DATE: October 2, 2019

TO: Kari Parsons, PCD-Project Manager

FROM: Kyle R. Campbell, P.E. – Division Manager

SUBJECT: Response to “**PUDSP-19-004 – Midtown Collection at Hannah Ridge Second Submittal**”, dated September 9, 2019

Vertical text on the left margin: Dwp that down to average 2080, These are notes; lot size was already noted above.

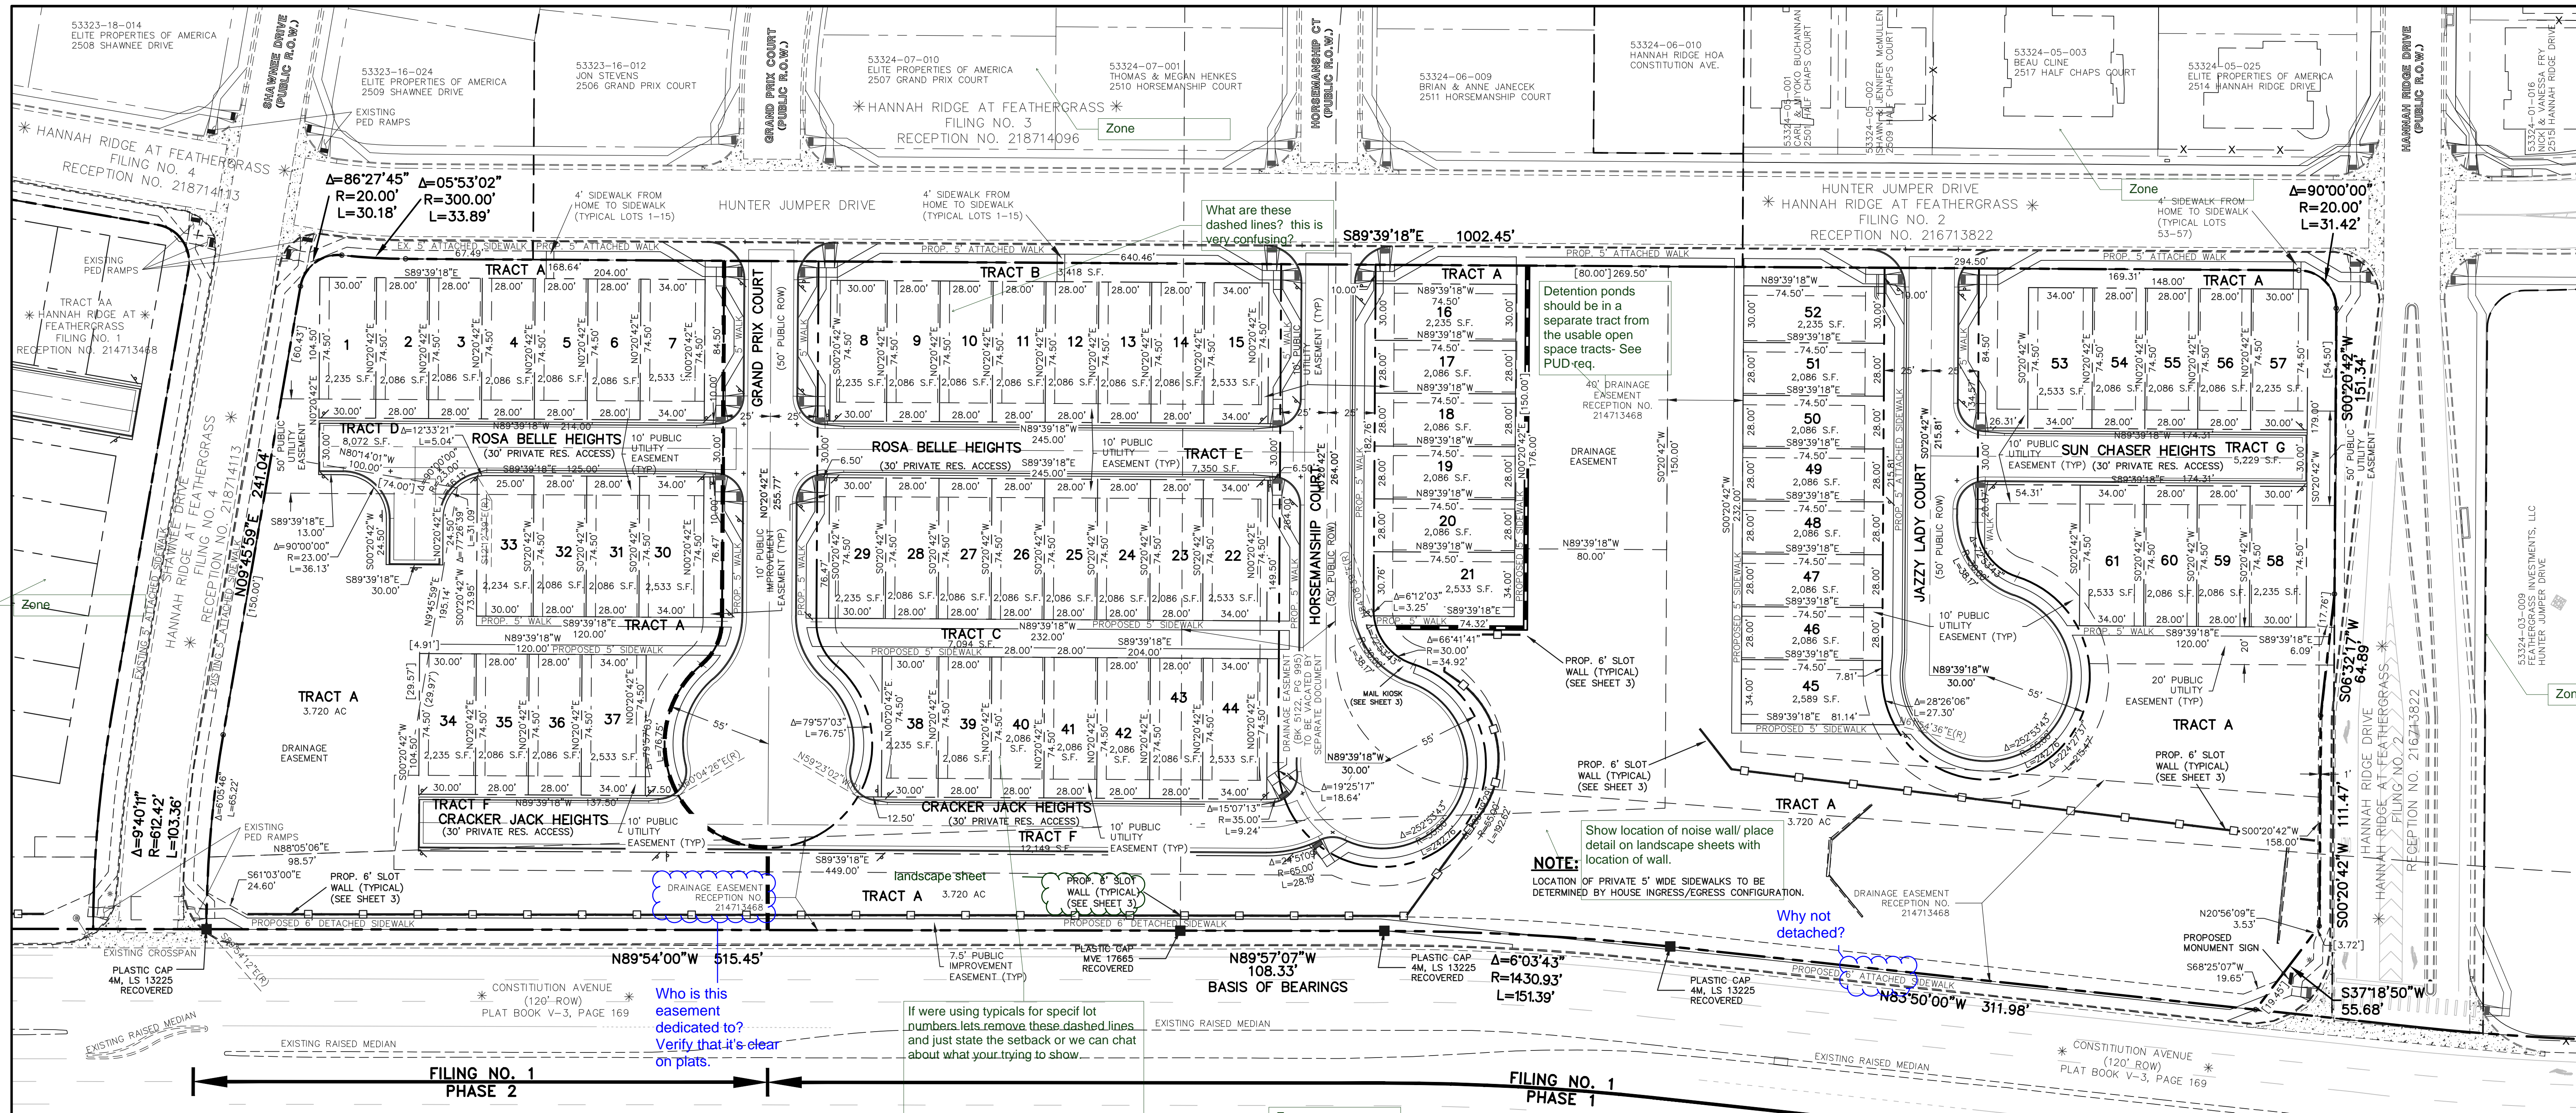
1. **through 3 – Resolved.**
4. See PUD-SP electronic redlines for additional comments. **Partially resolved; see updated/remaining redlines.**

**RESPONSE: Sheet 2 - “setback” added to Typical Lot Detail for clarity. The Garage is not within the 20’ setback, allowing for a 20’ driveway. The optional second story balcony is the item the comment was pointing. Sheet 4 – Drainage Easements and labels were added as requested. Access roads added to maintain ponds and existing rip-rap / headwall structure.**

MIDTOWN COLLECTION AT HANNAH RIDGE
 FILING NO. 1
 DEVELOPED CONDITIONS DRAINAGE MAP

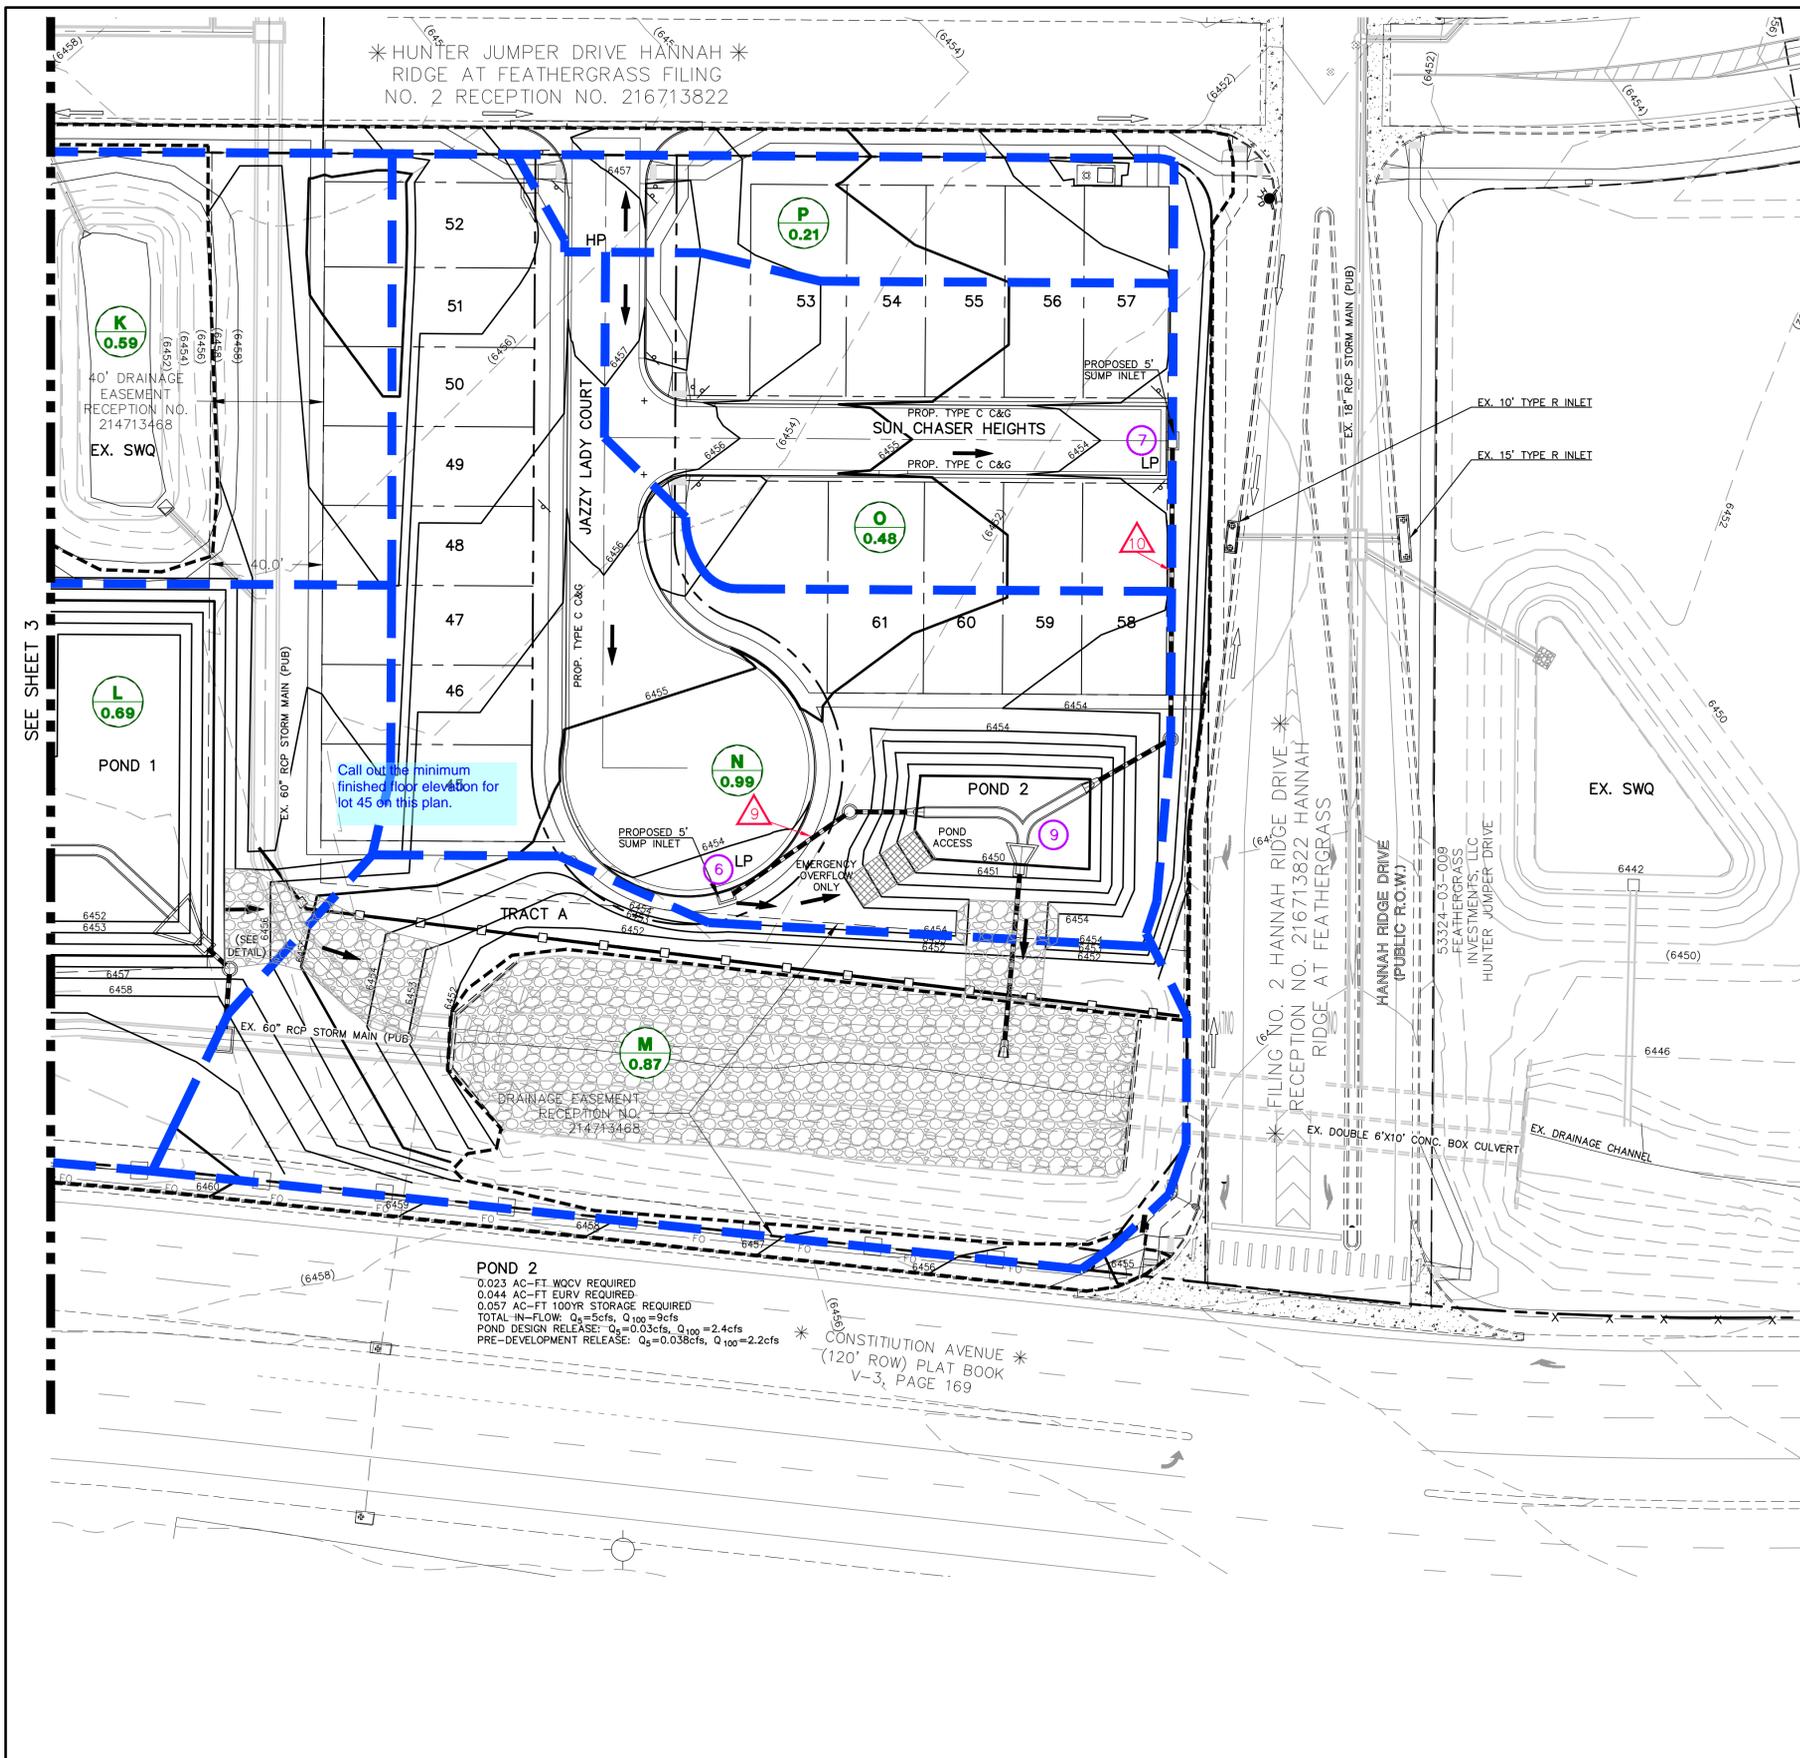
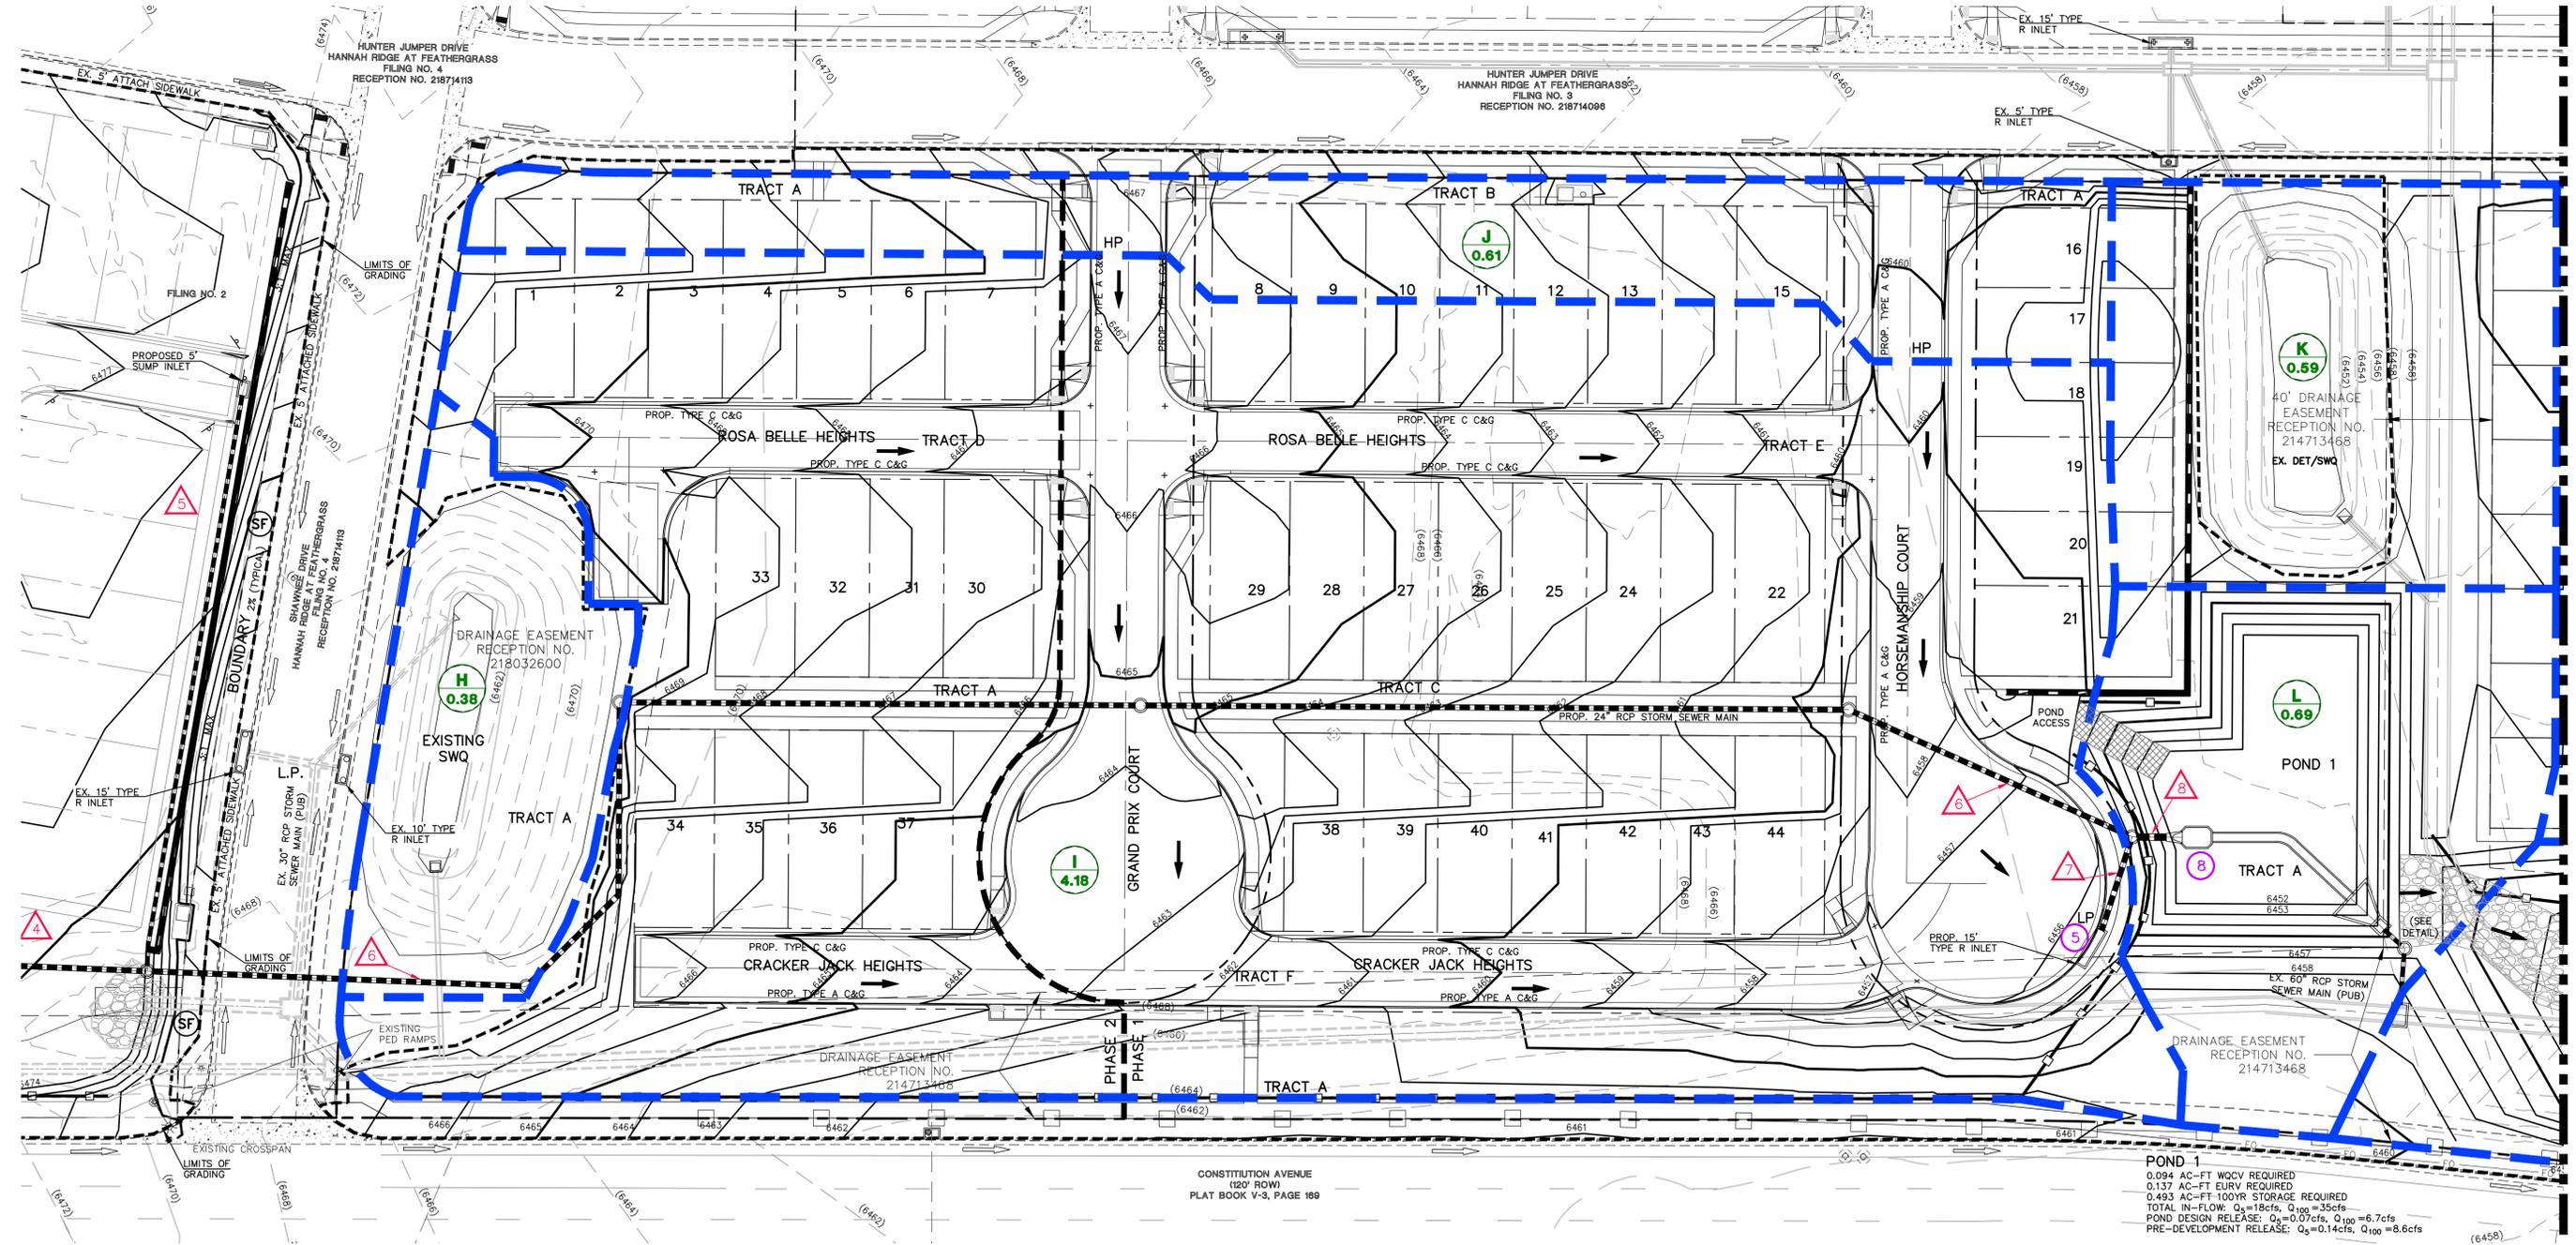
2. The untreated areas need to be less than 1 acre in size and less than 20% of the developed area. **Unresolved; Basin outfalls were minimally modified from the first to the second submittal. Please provide a table on the drainage plan that verifies the 1 acre/20% requirement is met.**

**RESPONSE: Table added as requested.**
